25 October 2019

SSD 7484 – MODIFICATION 4 RESPONSE TO SUBMISSIONS AND REQUEST FOR FURTHER INFORMATION 23-33 & 35-39 BRIDGE STREET, SYDNEY – THE SANDSTONE PRECINCT

Heritage Interpretation
Courtyard Gantries

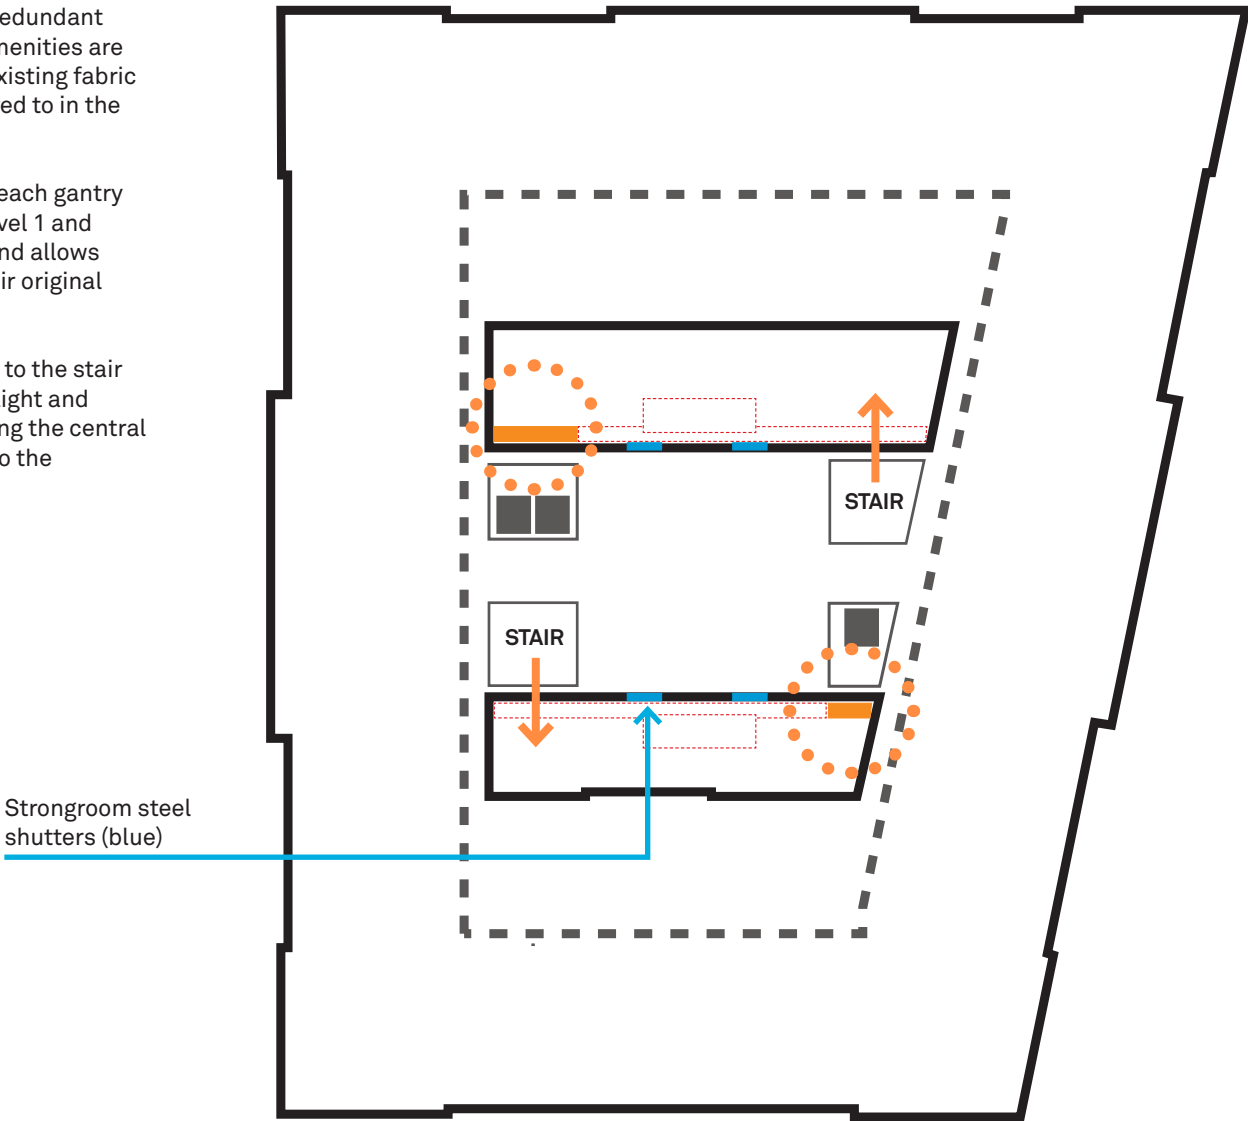
<p>The courtyard toilet structures and related iron gangways are early fabric and are not without significance. While 'cleaning up' the internal facades acknowledges their proposed public presentation to the court yard circulation network, it should not remove all evidence of historic use. Retention of some ironwork in situ should be considered for interpretation. Substantial elements of the iron gangways, including the brackets should be salvaged for interpretation on site and the toilets should be covered in the revised interpretation plan.</p>	<p>The heritage significance of the toilet structures and iron gangways is acknowledged and it is confirmed that interpretation of these elements including retention of some ironwork in situ and an interpretation of the toilet structure footprint in the paving is being explored. Refer to Attachment F for further details.</p>
Waste	
<p>Council requests that conditions C9 and F17 are amended to reference Council's Guidelines for Waste Management in New Developments 2018 to ensure that demolition, construction and operational waste management is undertaken in accordance with the City's requirements.</p>	<p>It is confirmed that the submitted Operational Waste Management Plan is based on Council's Guidelines for Waste Management in New Developments 2018. It is noted that relevant conditions were amended to reflect 'general' compliance with Council's Waste Guideline. The Operational Waste Management Plan has been updated to ensure it is clear that these Guidelines have been incorporated (Attachment E).</p>

Department of Planning, Industry and Environment	Response
3 October 2019 Request for Further Information	
<p>Provide further detail of how the courtyard iron work interpretation is being explored, in response to Council's request that the ironwork (toilet structures and gangways) should be salvaged for interpretation. This could be through a proposed condition or amended interpretation plan.</p>	<p>The majority of the gangways are planned to be removed. Their purpose was to provide access to the toilets, so once the toilets are removed the gangways are effectively redundant. Some of the fabric is in poor structural condition (refer GBA Heritage Conservation Management Plan 2016). The revised design retains a portion of them at each level, using the best original fabric, and allows these elements to be interpreted in their original position. Their removal improves the view through the windows to the stairwells and allows (for the first time) the central Strong Room with its elaborate steel shutters to be clearly seen from the courtyard space. The retained gantry elements are located in the south-west corner of the north courtyard and the north-east corner of the south courtyard.</p> <p>The toilet structure will be reinterpreted in the paving pattern in the courtyard.</p> <p>Refer to Attachment F for further details to strategy for retention and interpretation.</p>
